Planning Act 2008 - application for a Development Consent Order for Mallard Pass Solar Farm: Action from Issue Specific Hearing 4 – Environmental Matters (Day 1)

We note the Action to the Applicant and the Environment Agency resulting from Issue Specific Hearing 4:

‘Results of further liaison between the Applicant and the Environment Agency regarding flood risk implications of the operational time limit.’

Figure 1 - 0.5% AEP Extents

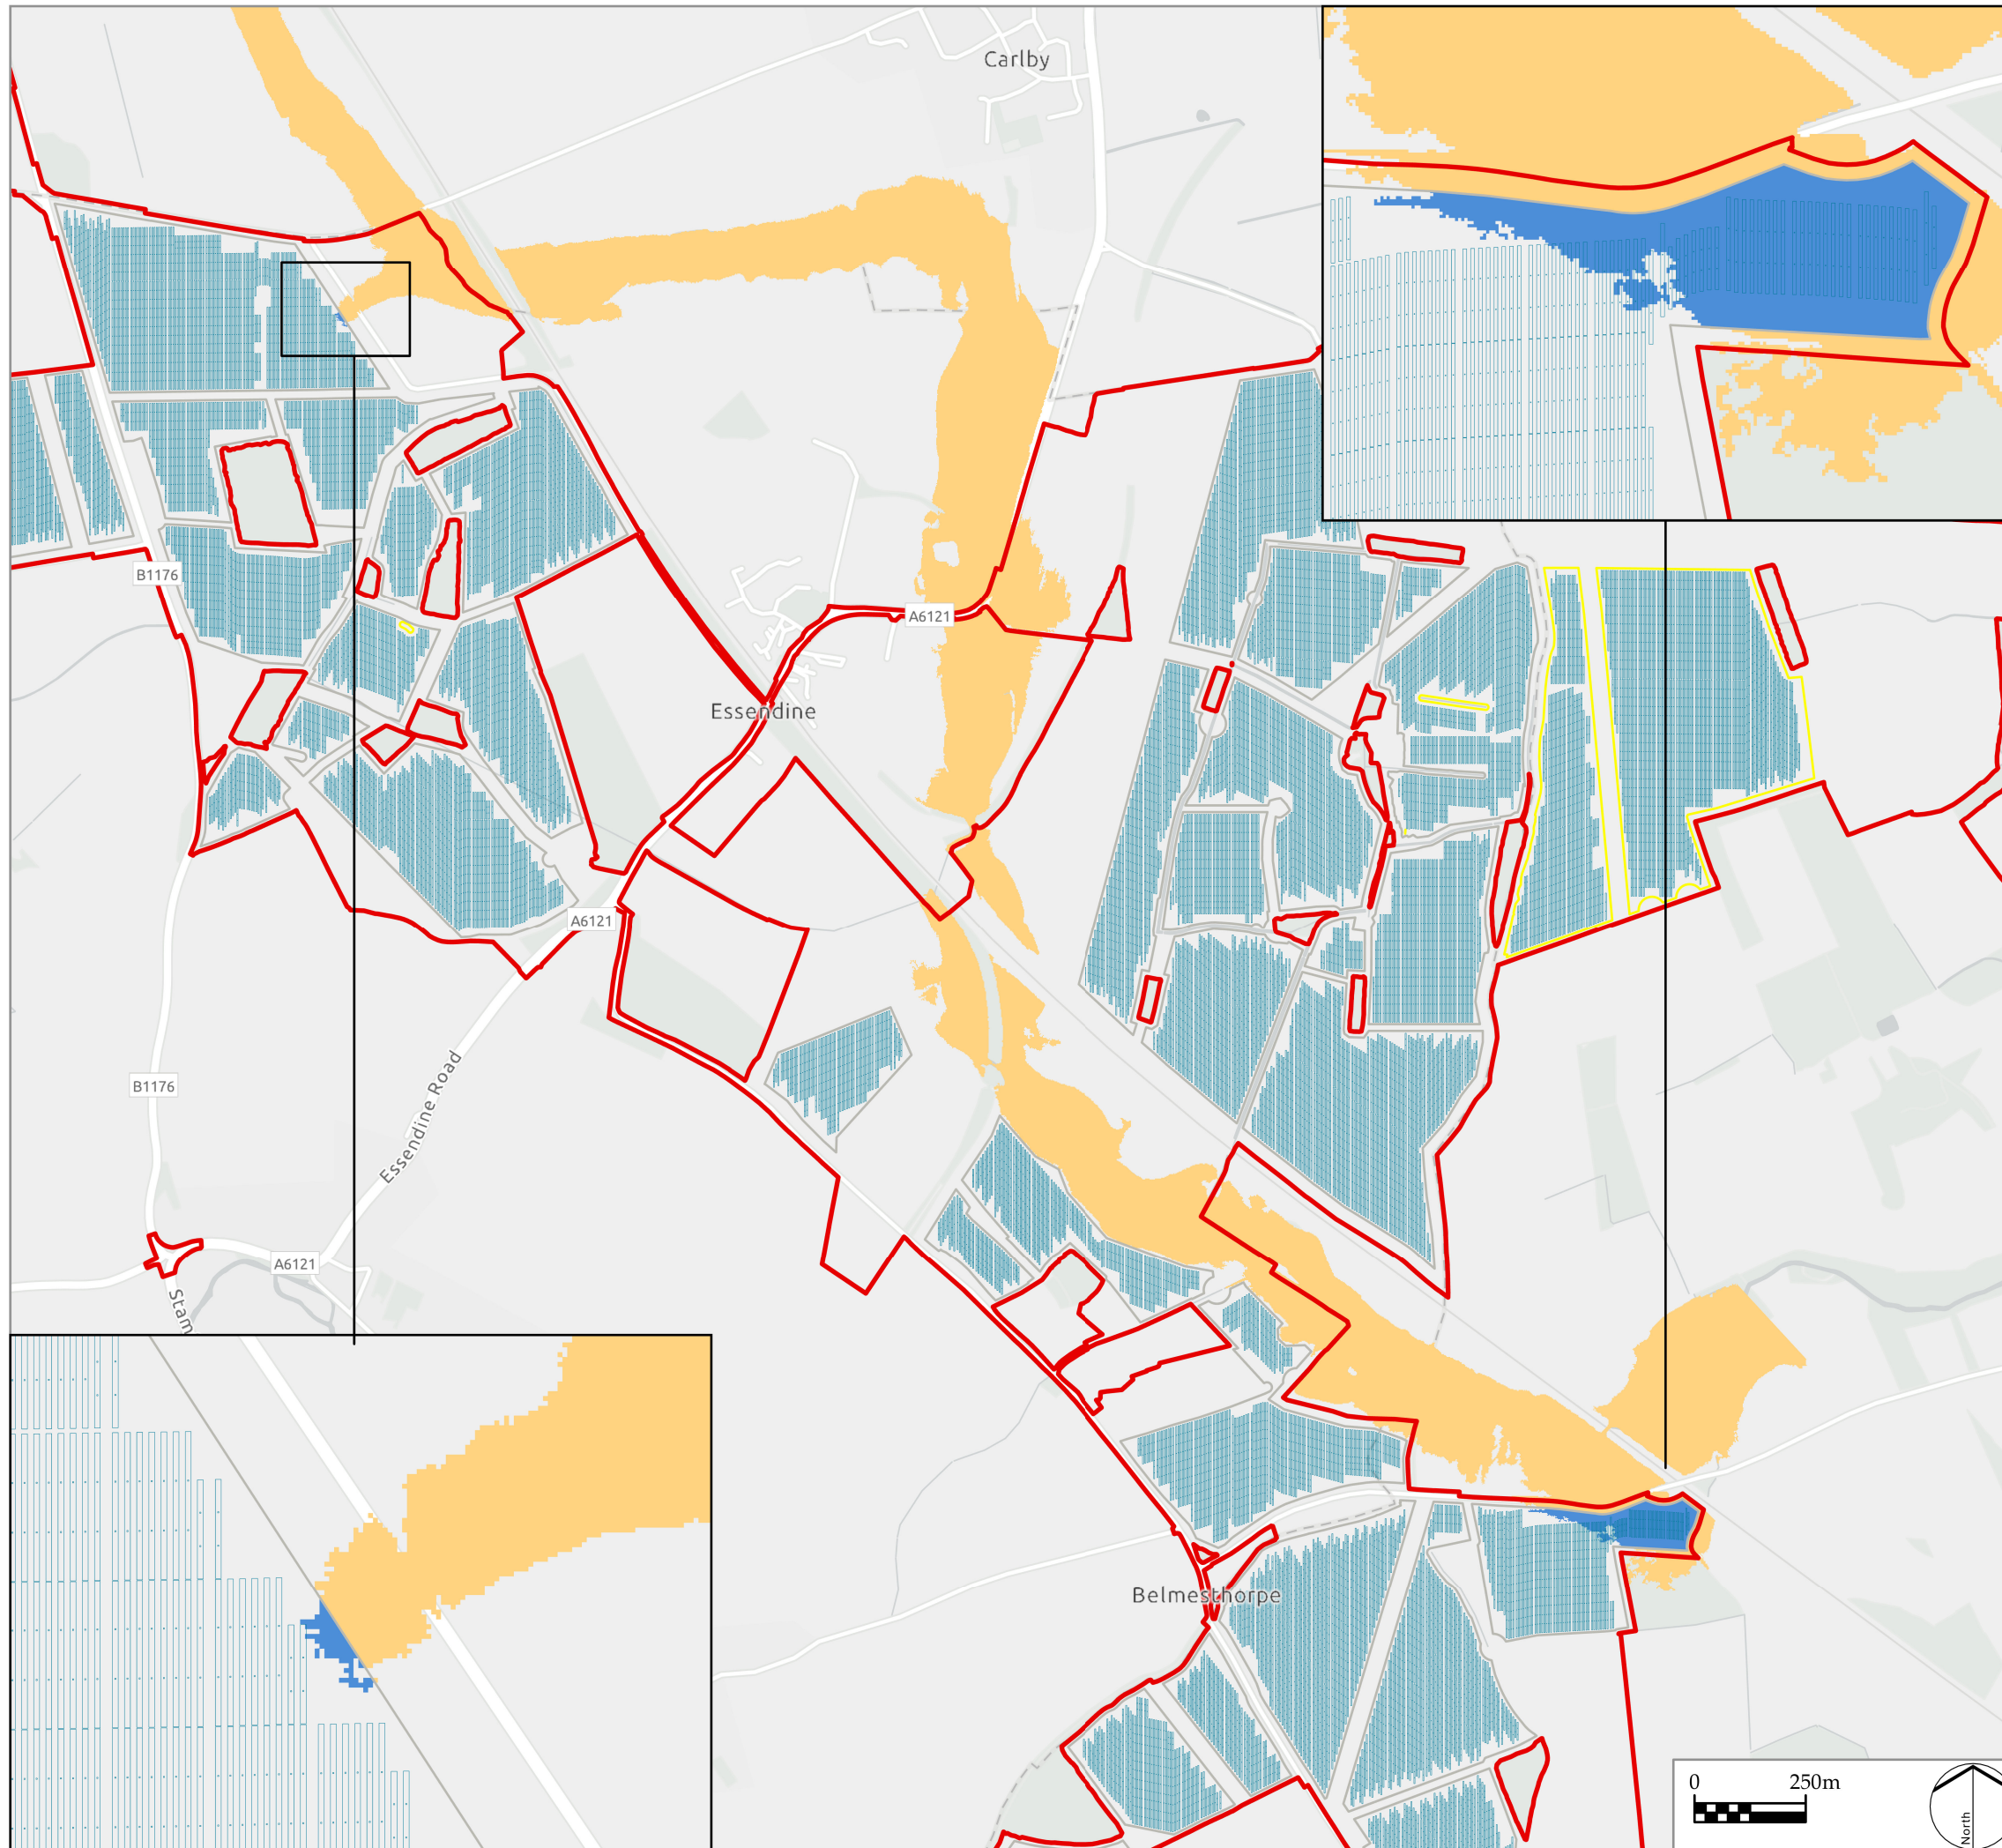
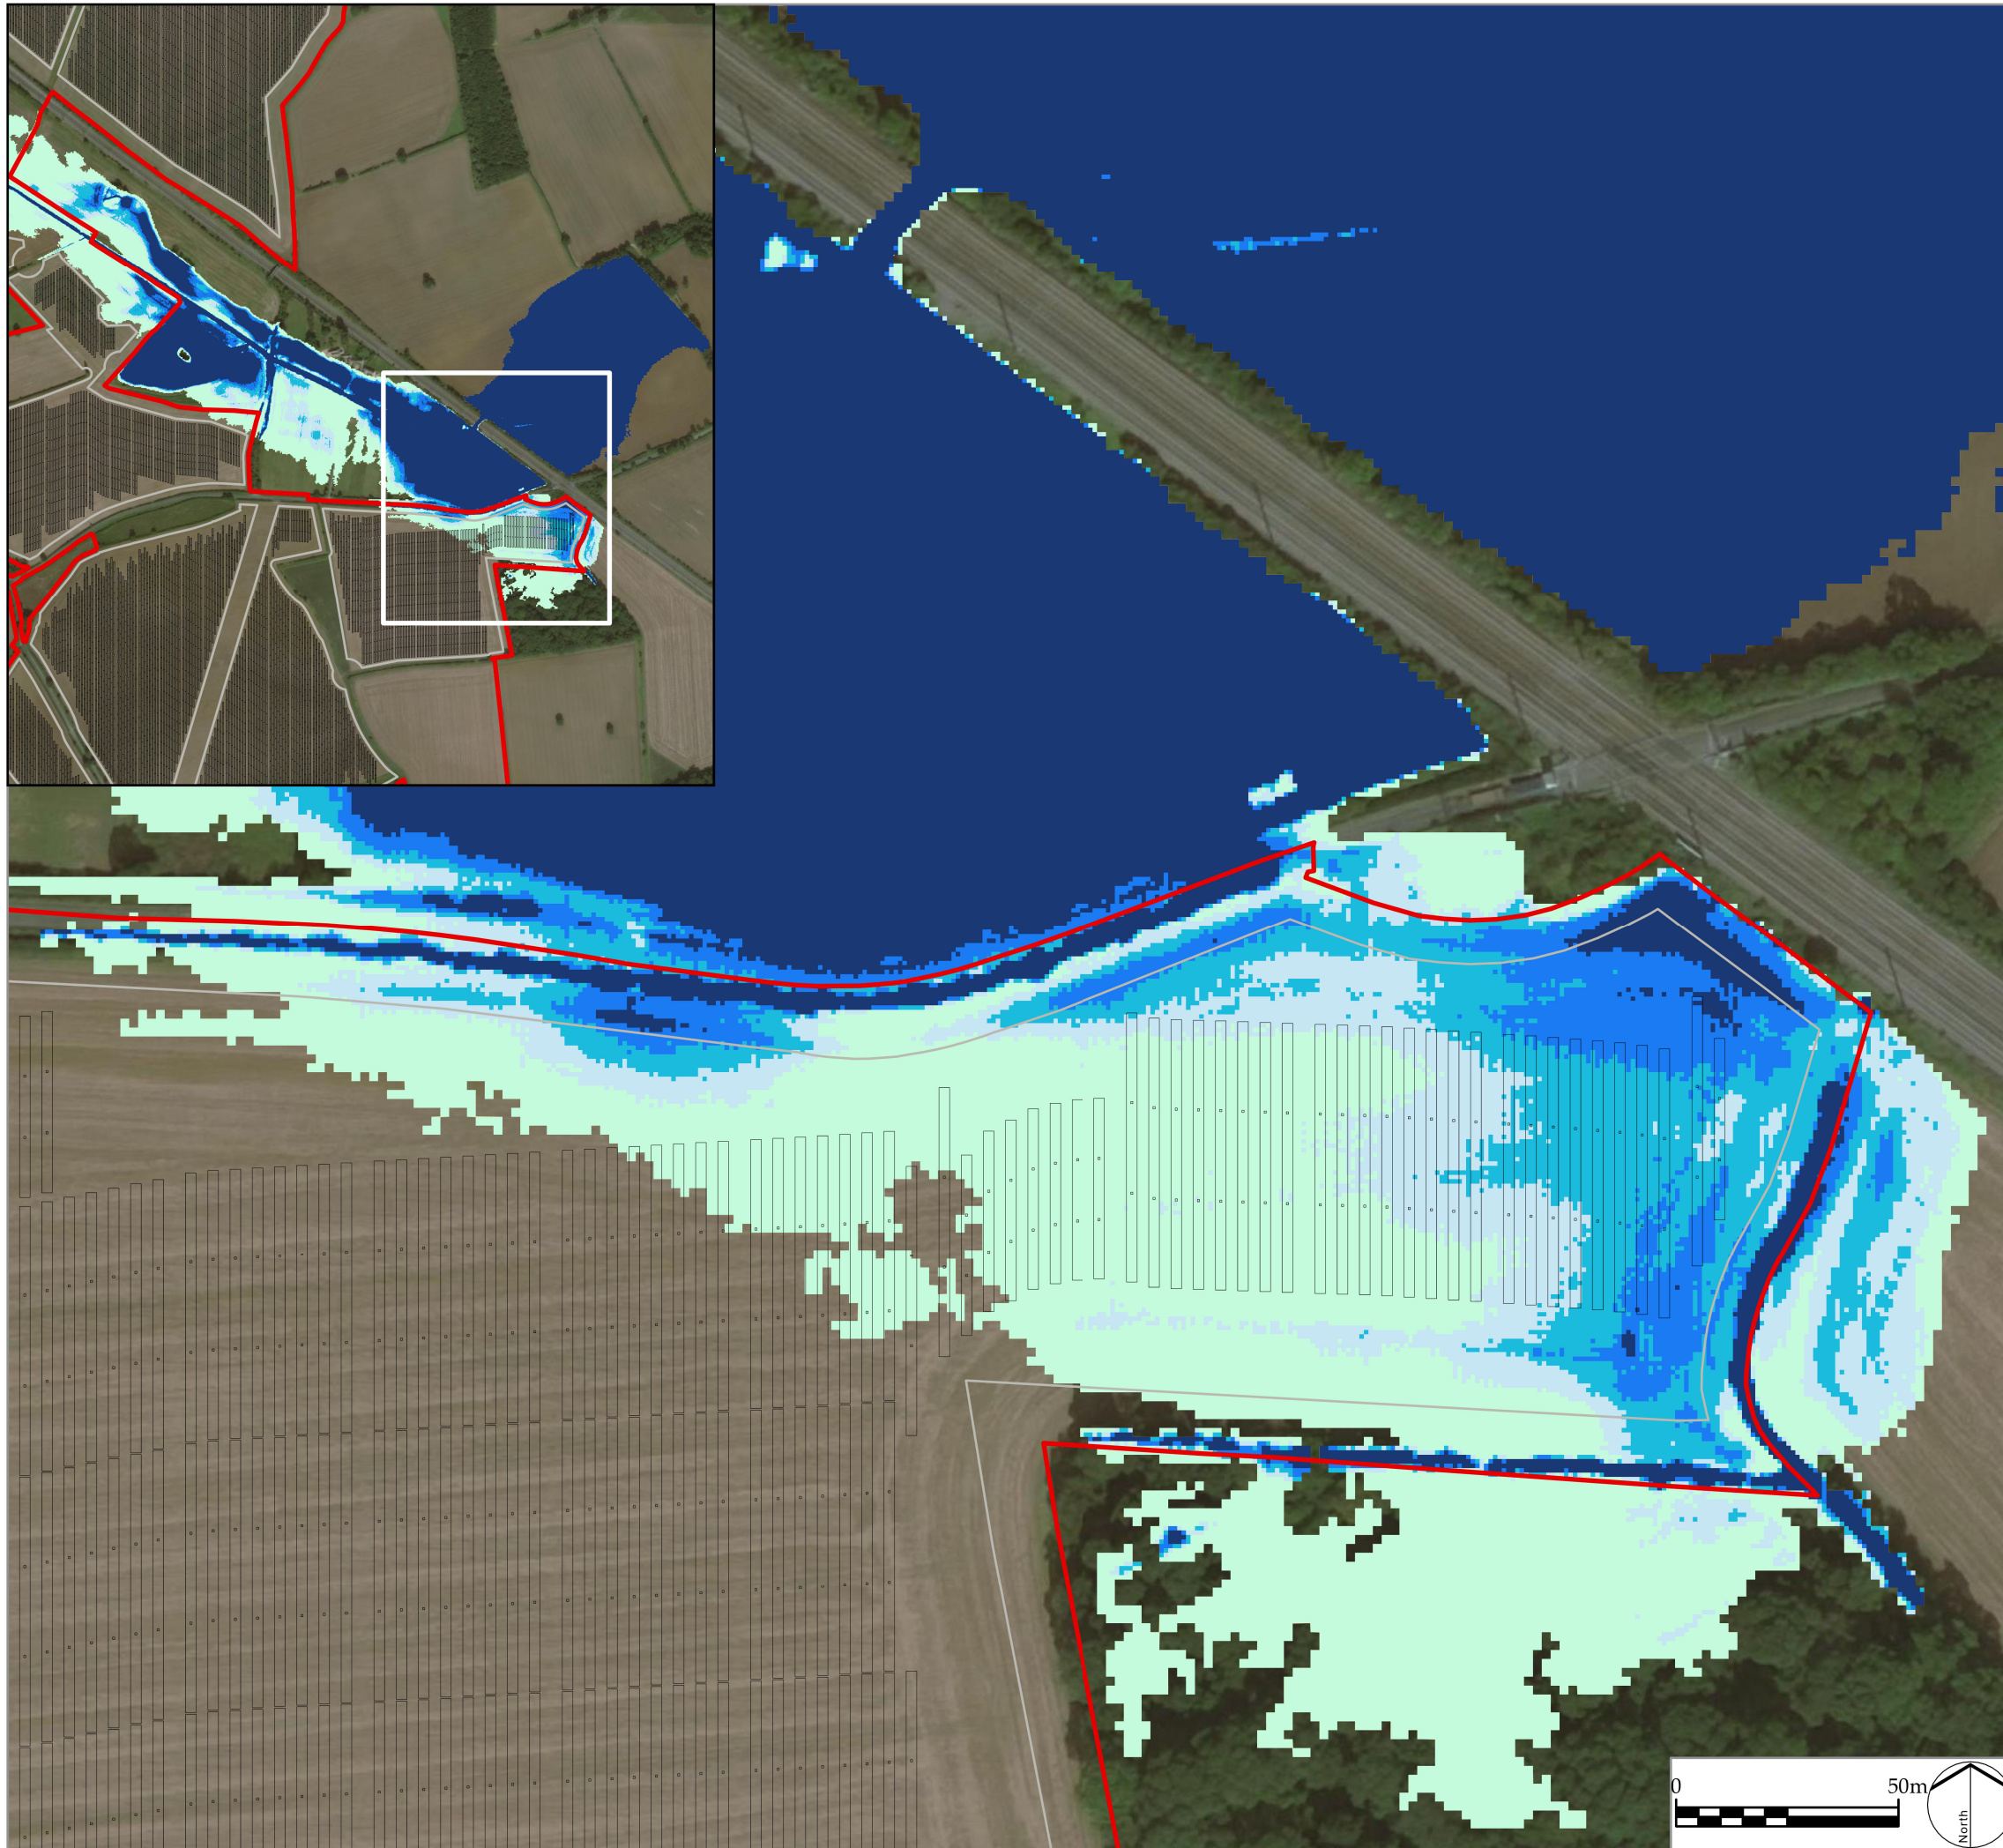
The Applicant has now informed us that they have analysed and applied the 1:200-year (0.5% annual probability) flood levels to the existing ground profile, as a proxy for the 1:100-year (1% annual probability) event plus a 28% climate change uplift. They have stated their intention to submit this analysis at Deadline 7.

We are happy with this proposed approach and will review the submitted analysis and results when published. Should the results indicate that any additional mitigation or amendments are required to the layout of the solar farm, these can then be discussed and agreed and the draft Development Consent Order updated accordingly.
